Notice of Modification

The development consent DA No. 308-12-2004-i granted by the Minister for Planning on 30 June 2005 for the Coca Cola Amatil Distribution Centre, as modified by DA No. 308-12-2004-i MOD 7.

MODIFICATIONS TO
APPROVED SITE PLAN

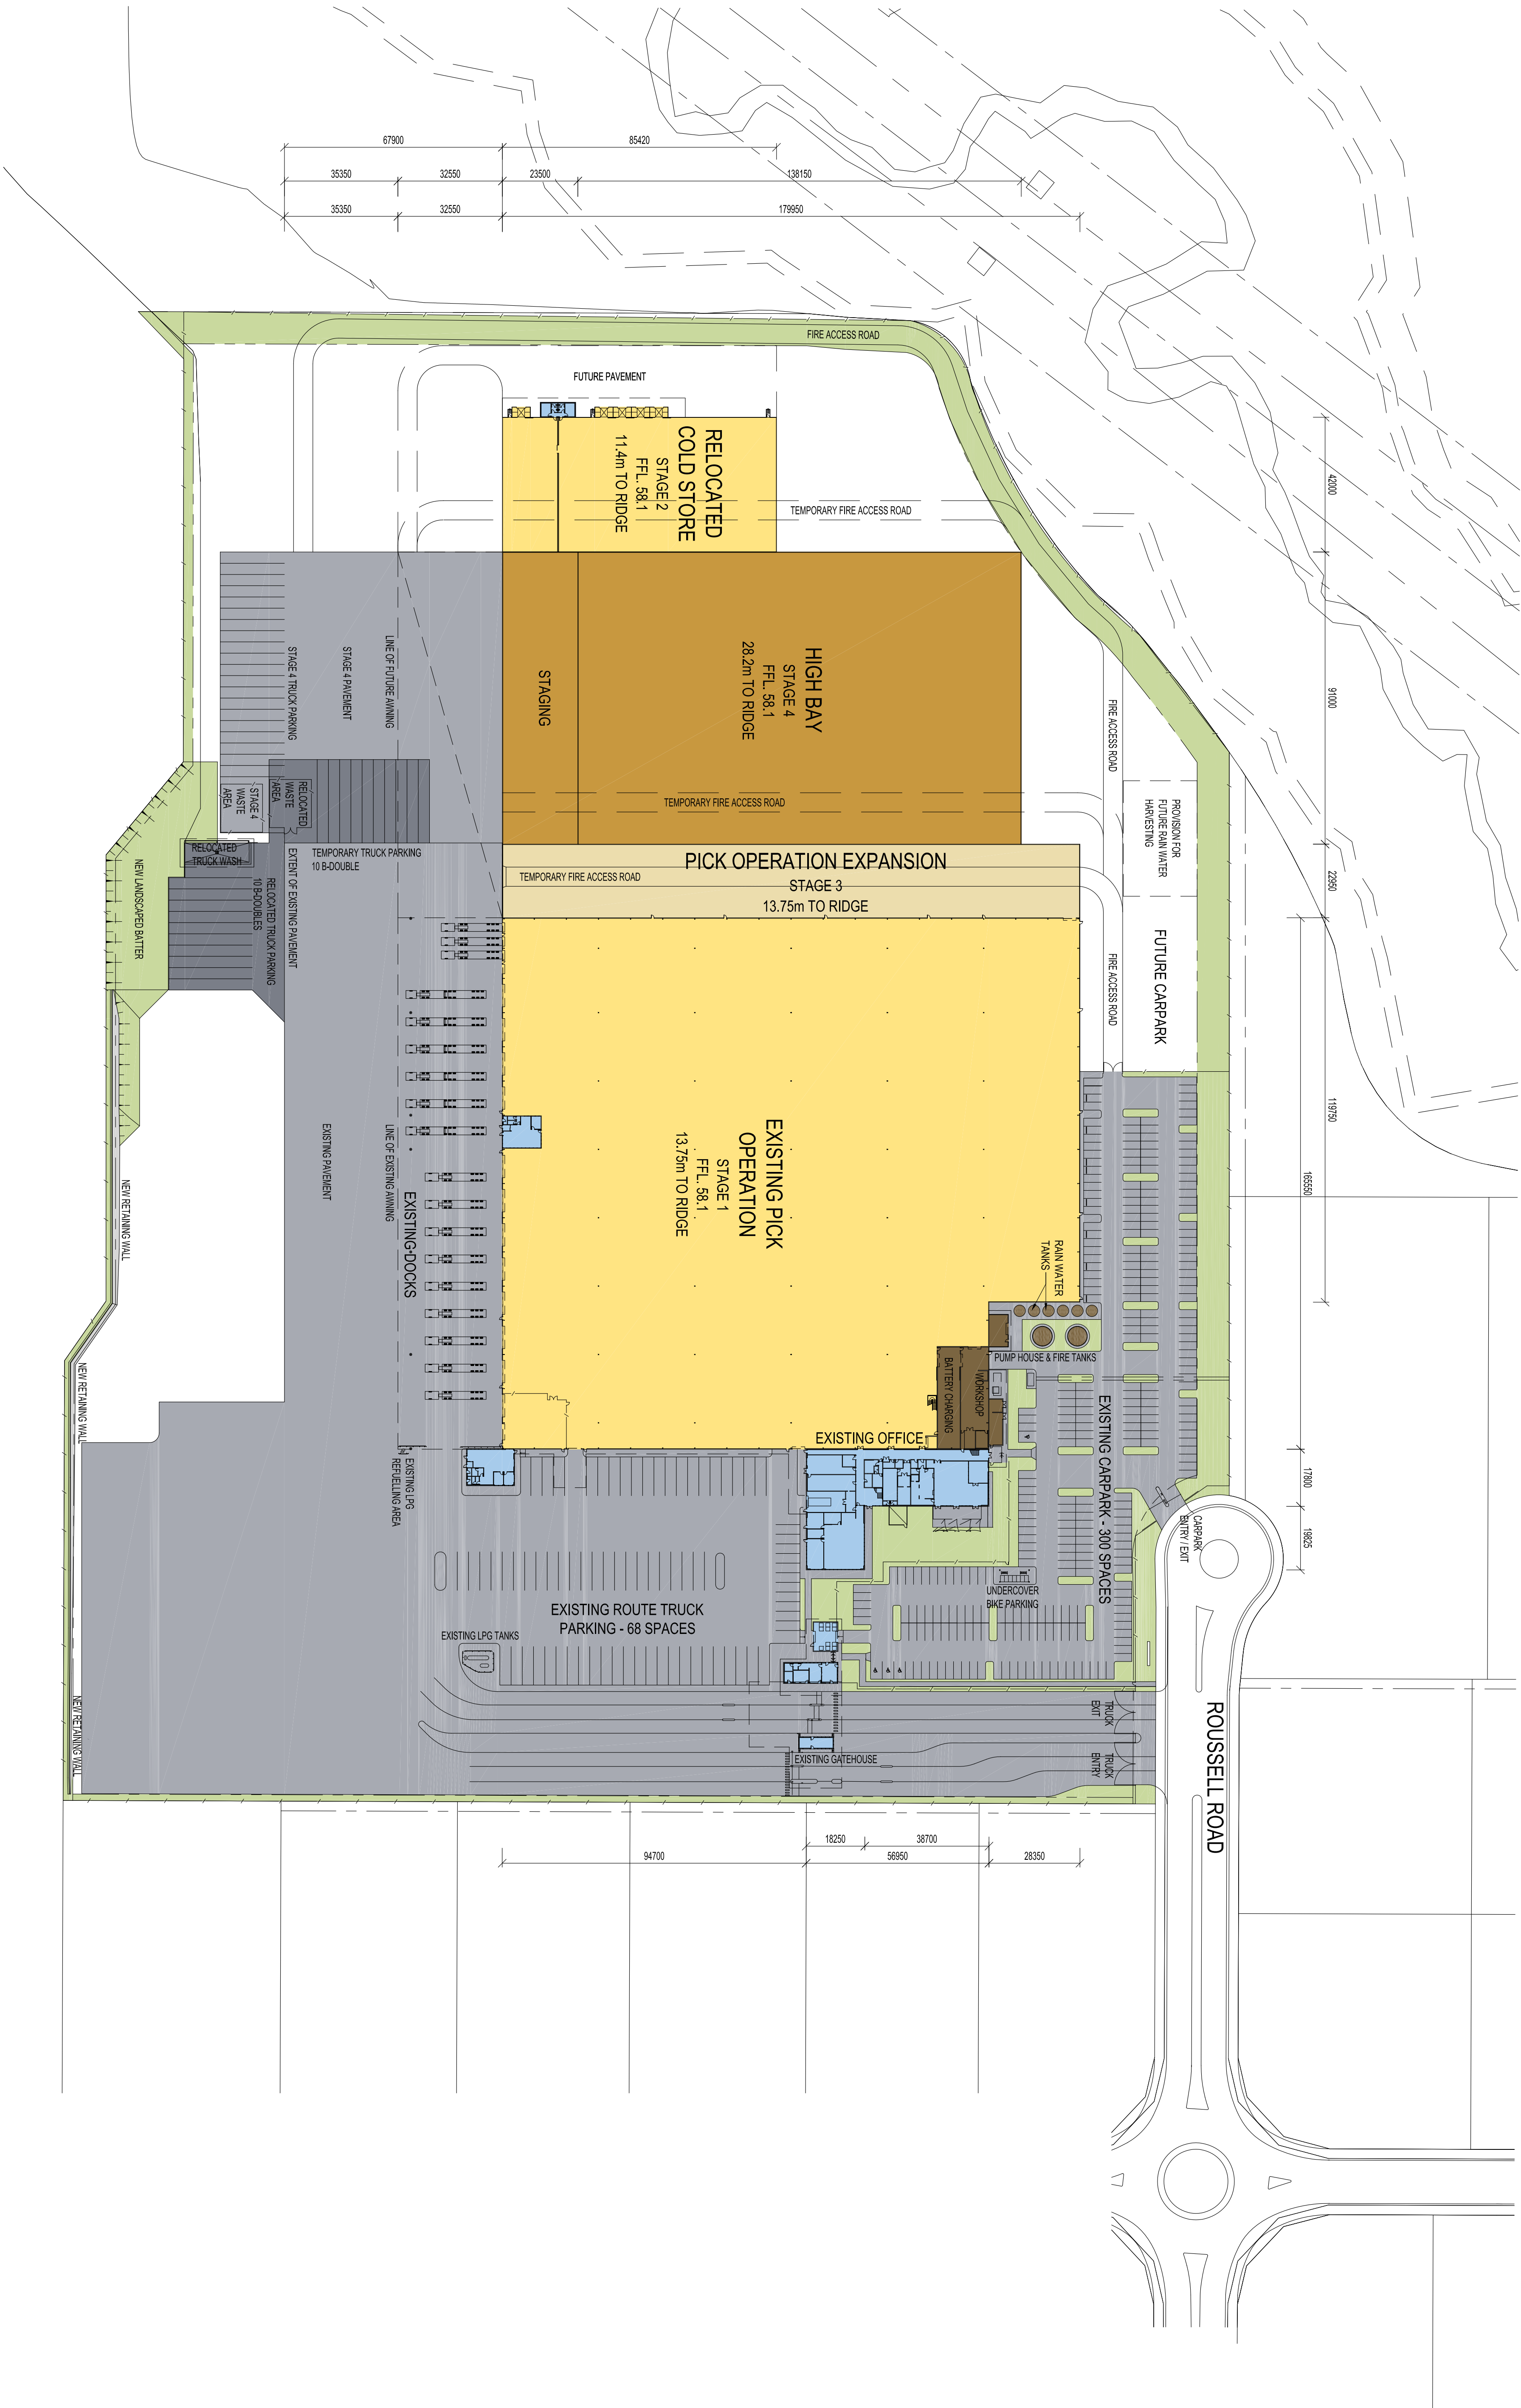
- submit the details, including plans, of the final site and floor levels of the relocated cold store building; and
- demonstrate that the final site and floor levels are justified and consistent with the findings and requirements of the Flood Impact Assessment undertaken by the Applicant for DA 308-12-2004-i.
